A1 in Northumberland TR010059

### **Northumberland County Council's Relevant Representation**

#### **Relevant Representation of Northumberland County Council under Section 56 of the Planning Act 2008 in respect of the A1 in Northumberland Development Consent Order Application.**

Revision: P02

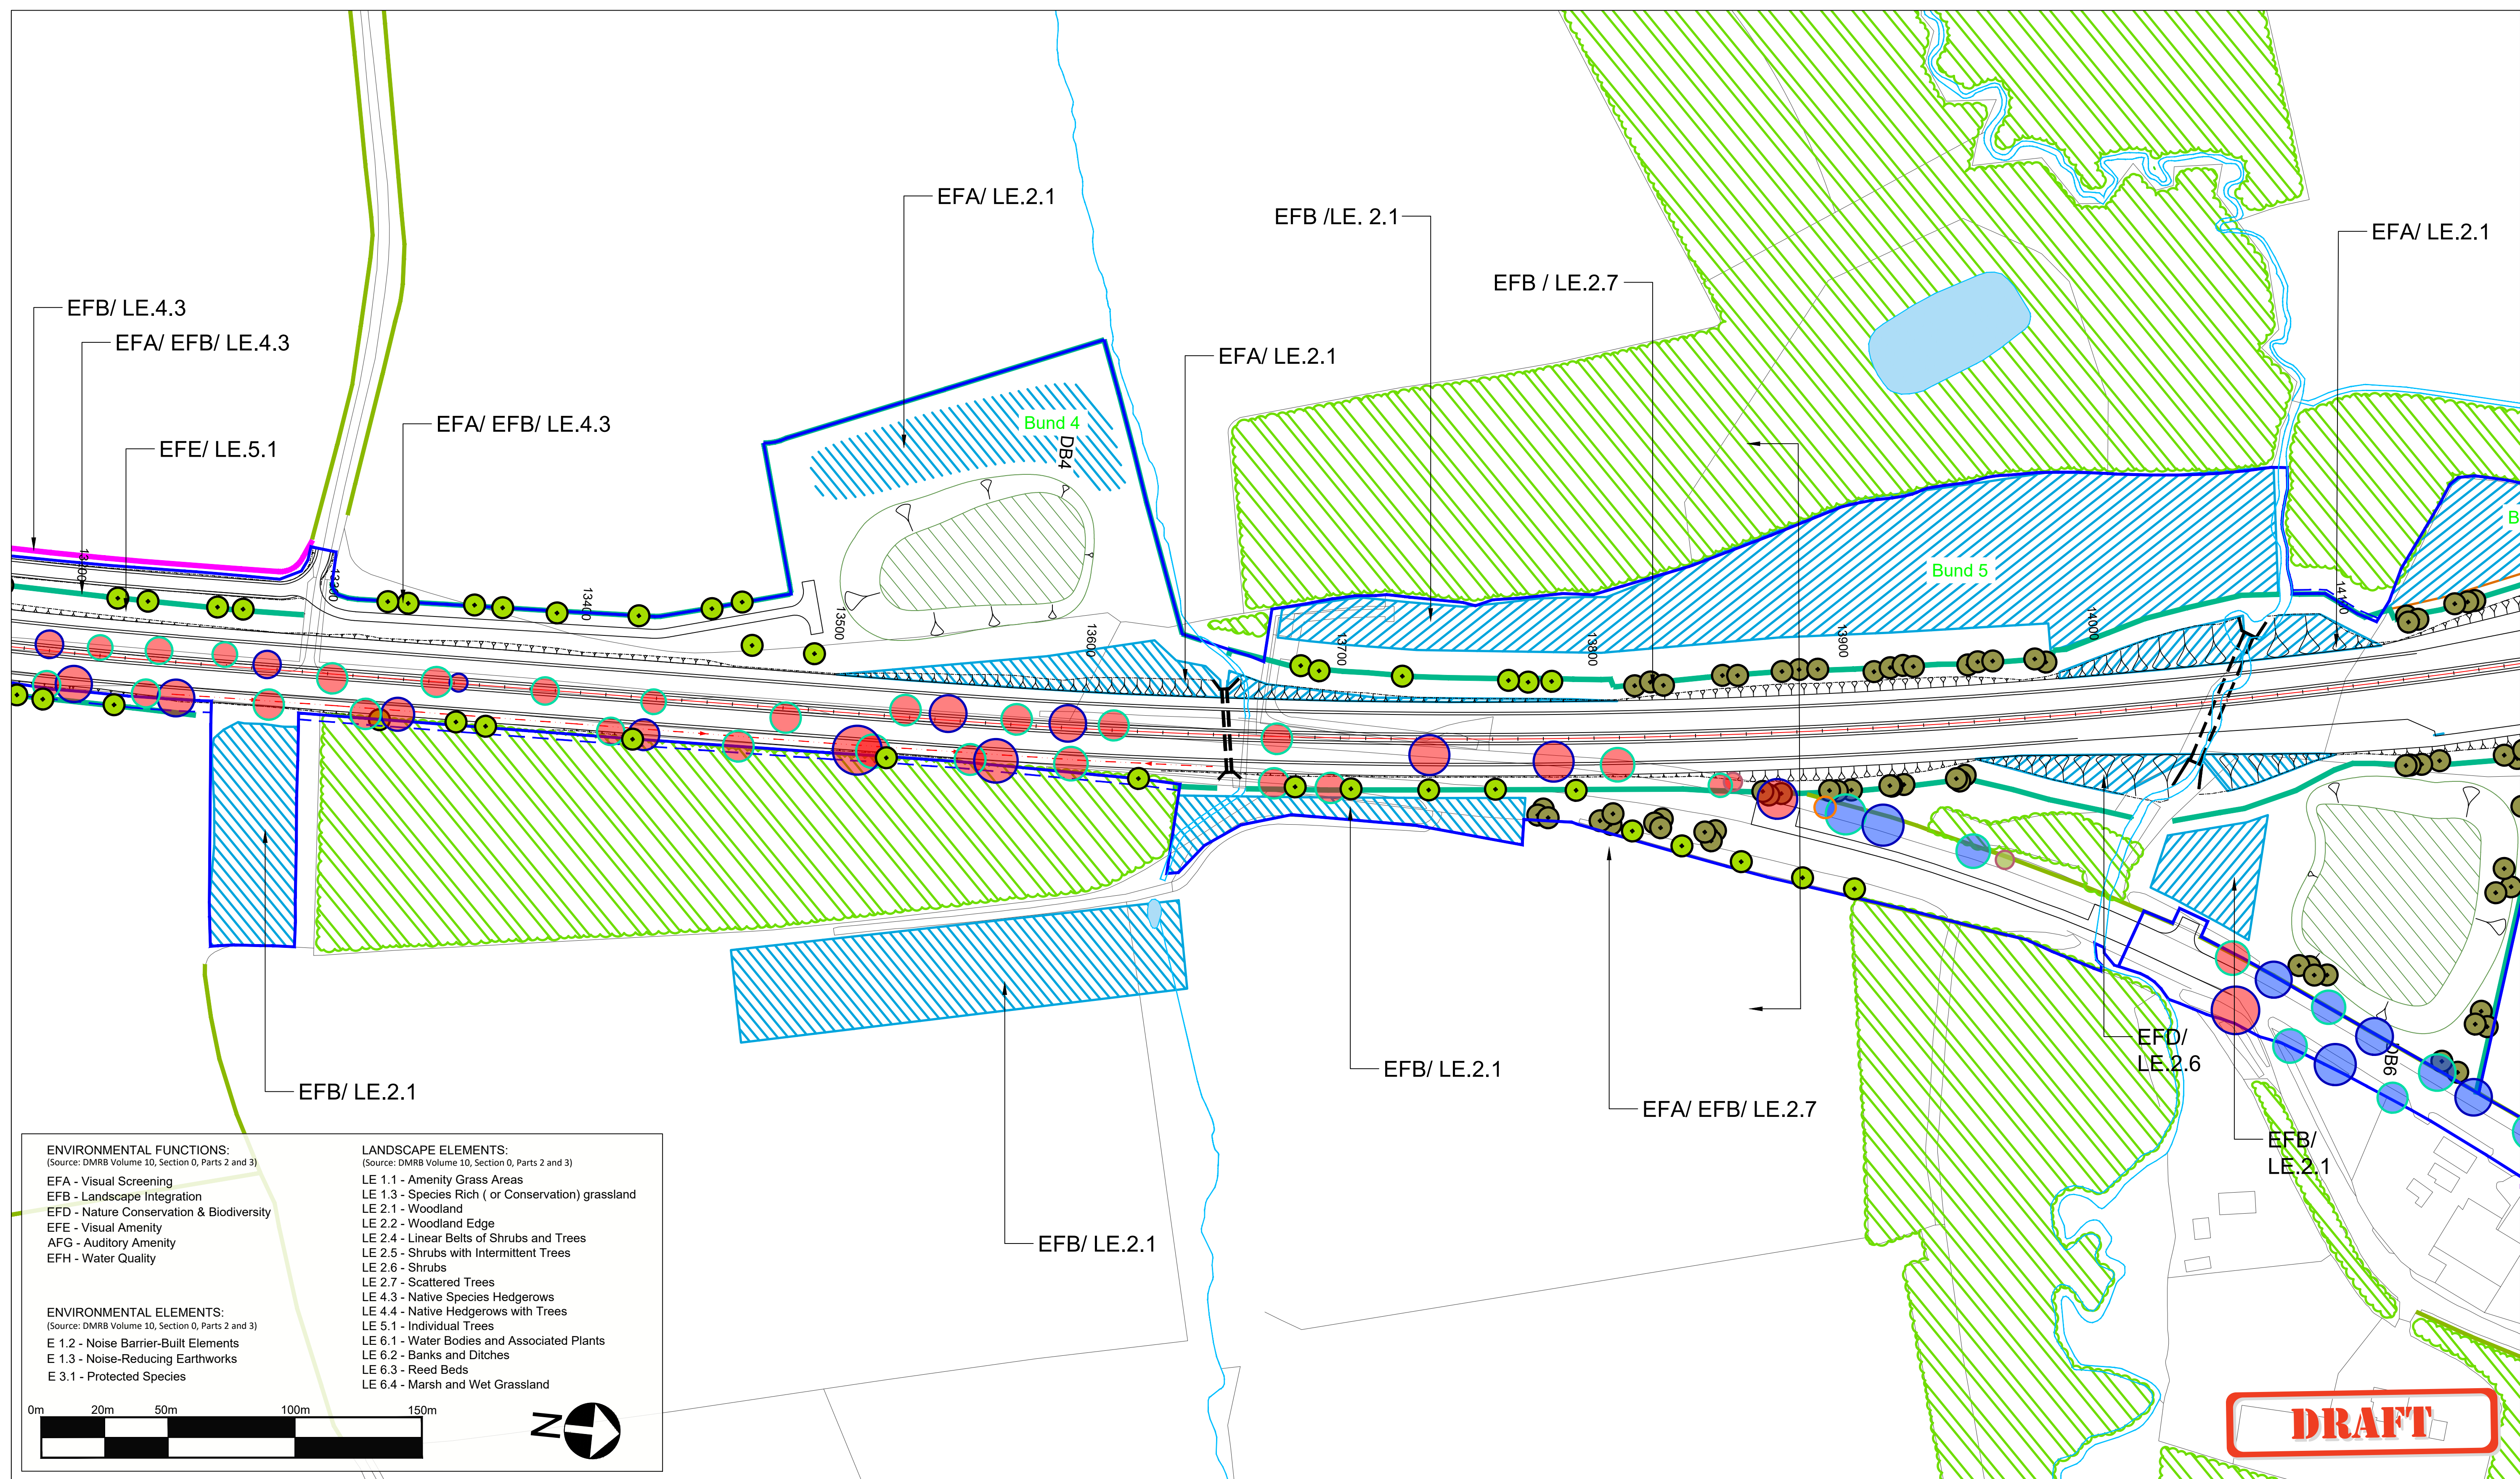
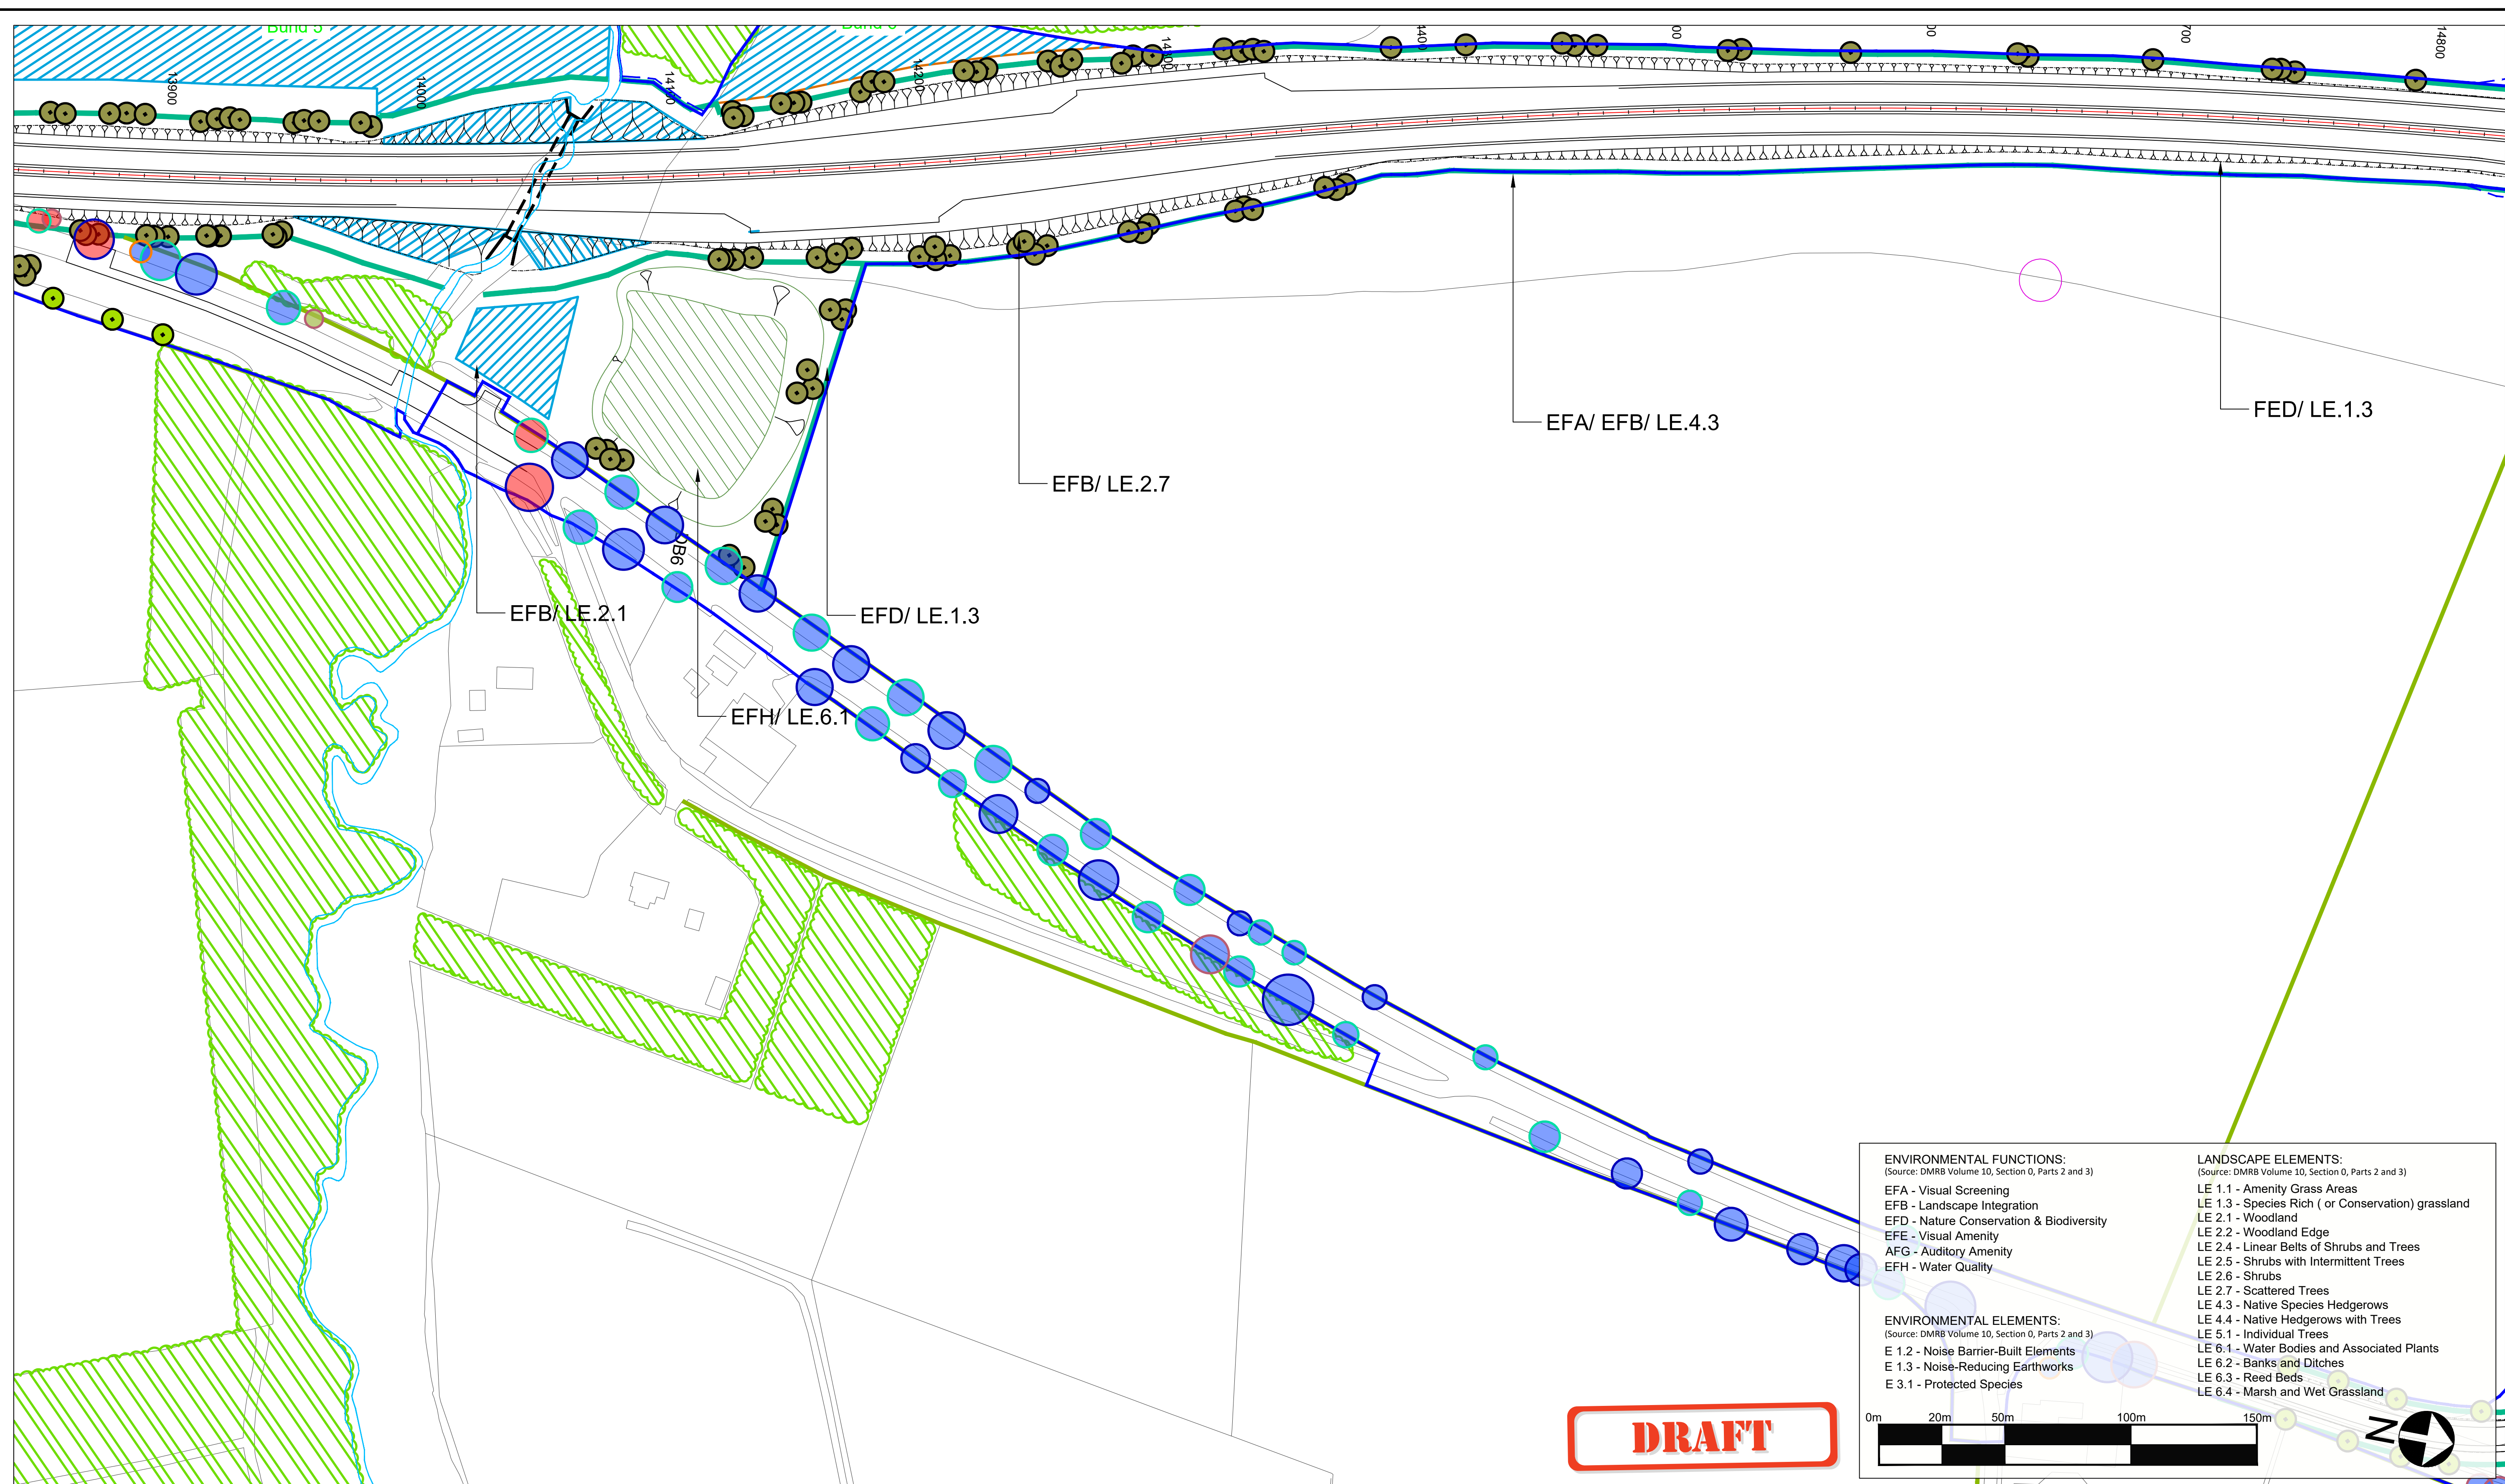
23. The replacement Coronation Avenue is a token gesture, consisting of trees spaced roughly every 100m. This avenue plays an important role in retaining a rural, well-vegetated character through this section of the route and the LVIA is quite clear about the local importance of the Avenue as a landscape feature and the sparse nature of the replacement compared to what is removed is not explained or justified in the application.

24. There is a lack of certainty and commitment in the landscape proposals, some of the bunds are described as 'desirable mitigation' and it is unclear as to whether they will be delivered or not. A number of the proposed hedgerows are marked as being 'by agreement' and the replacement avenue is described as 'currently proposed' and 'as appropriate and if required' suggesting that these elements are not a committed aspect of the proposals.
